Submissions Report

State Significant Development (SSD-69773460)

Mixed Use Development

35-37 Dwyer Street and 372-374 Mann Street, North Gosford

ISSUE PURPOSE	REV	DRAWING NO.
SSDA	A	DA 602

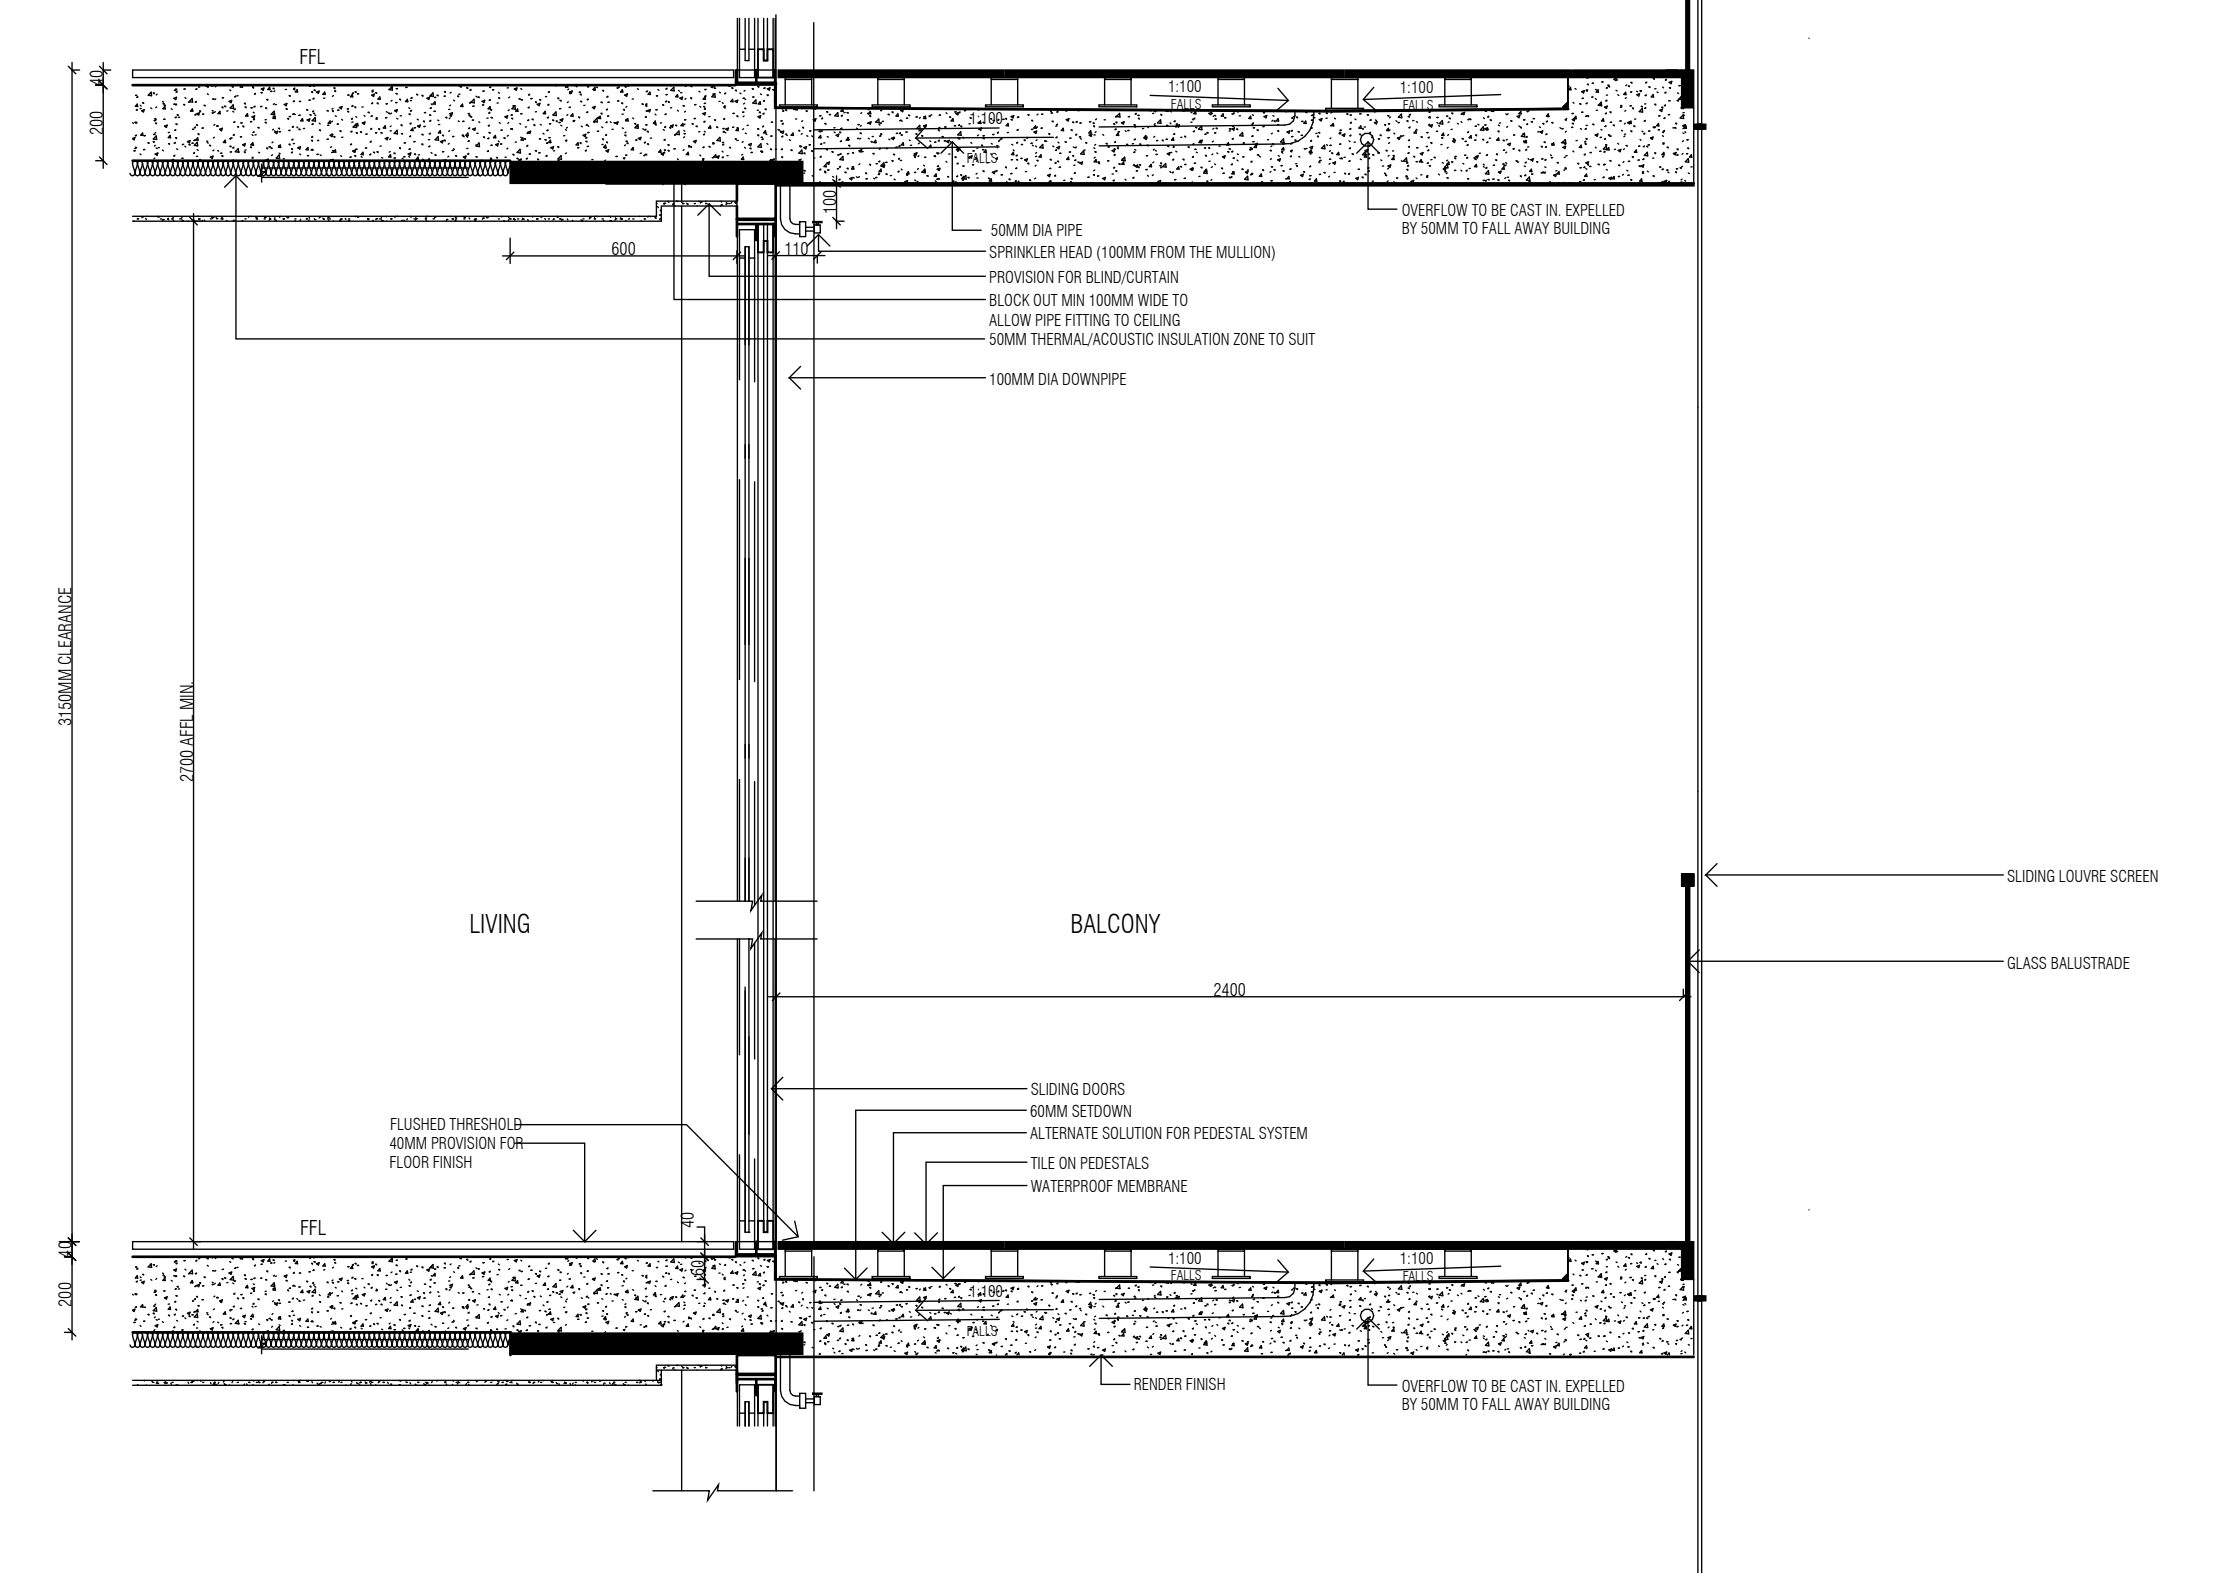
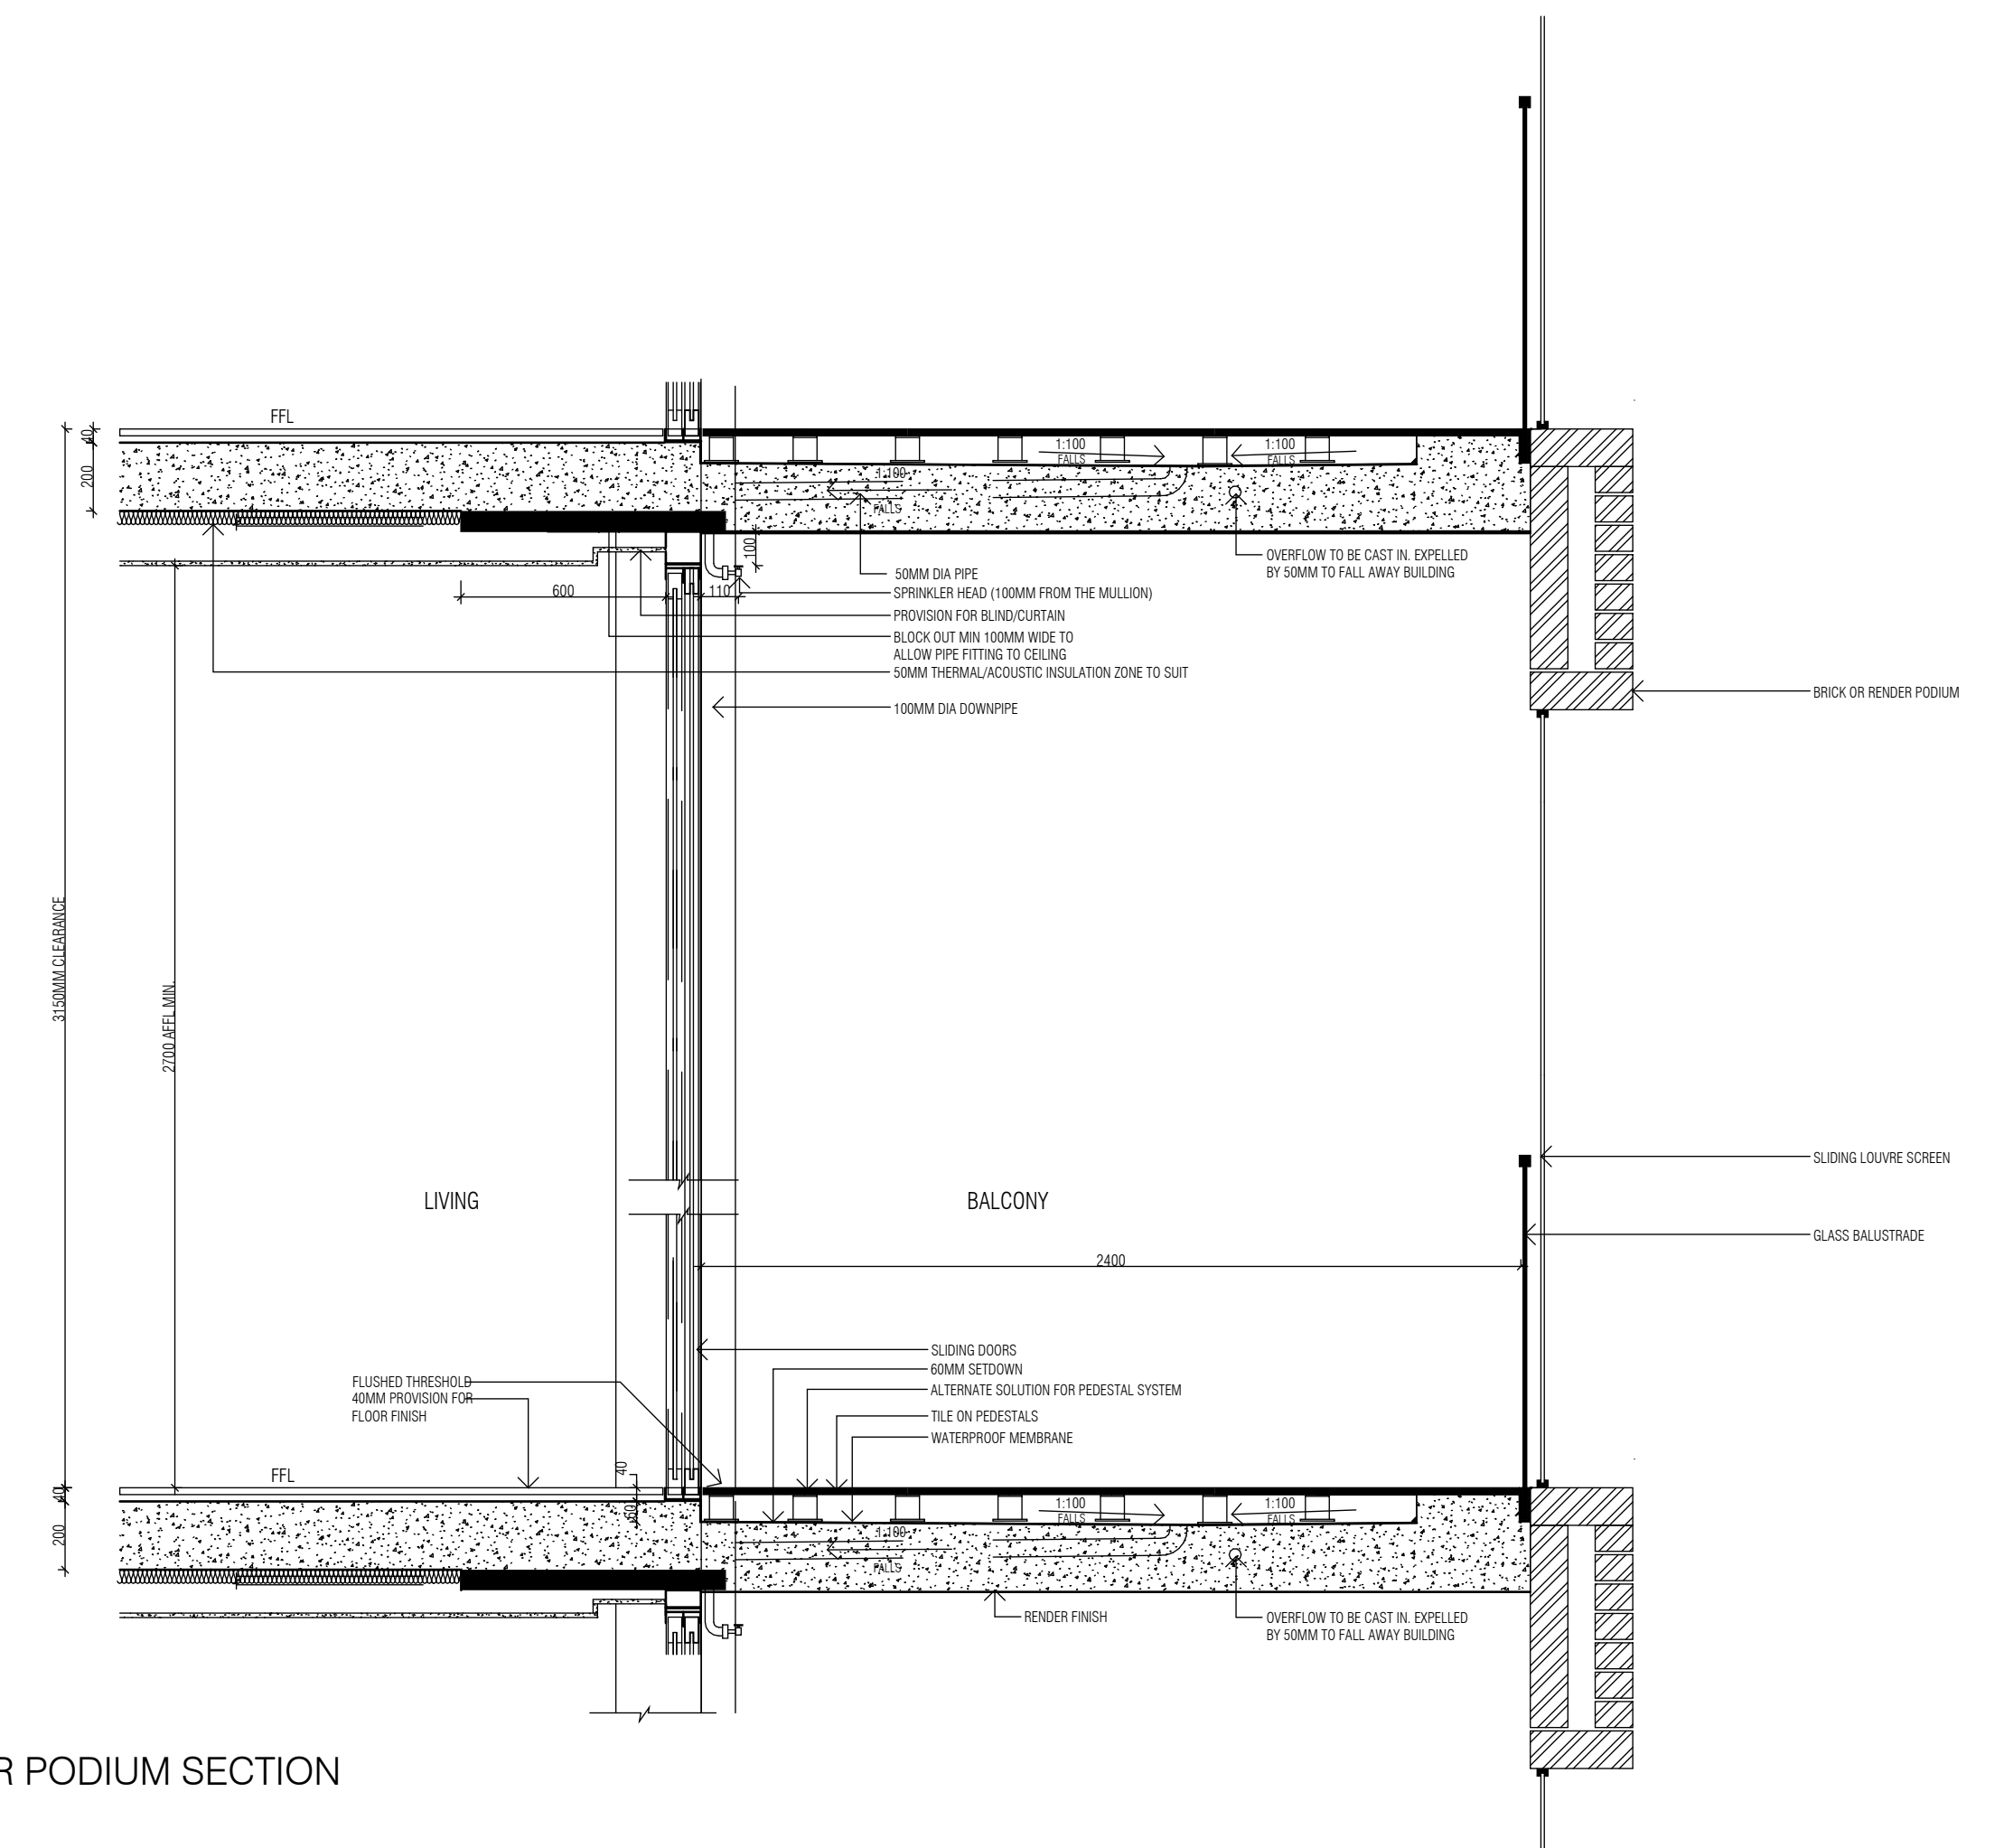
DPHI requested additional details on the Architectural Plans, relating to Sections for Buildings B2 and B3, a public domain staging plan and amended landscaping plans.

DPHI requested further details clarifying potential wind impacts on pedestrian safety and comfort within the plaza, public domain and communal rooftop. Additional information relating to sun shading, deep soil and tree canopy coverage is also requested as part of the DPHI RFI.

Additional section drawings have been prepared for Building B2 and B3 in relation to the balcony/shading detail (Refer to new Drawing No. DA-602) (**Attachment B**).

Amended sectional detail is provided for Buildings B2 and B3 in relation to sun-shading. An excerpt of new architectural drawing no. DA-602 is provided in **Figure 3. Section 4.2** provides a written response to the matters raised.
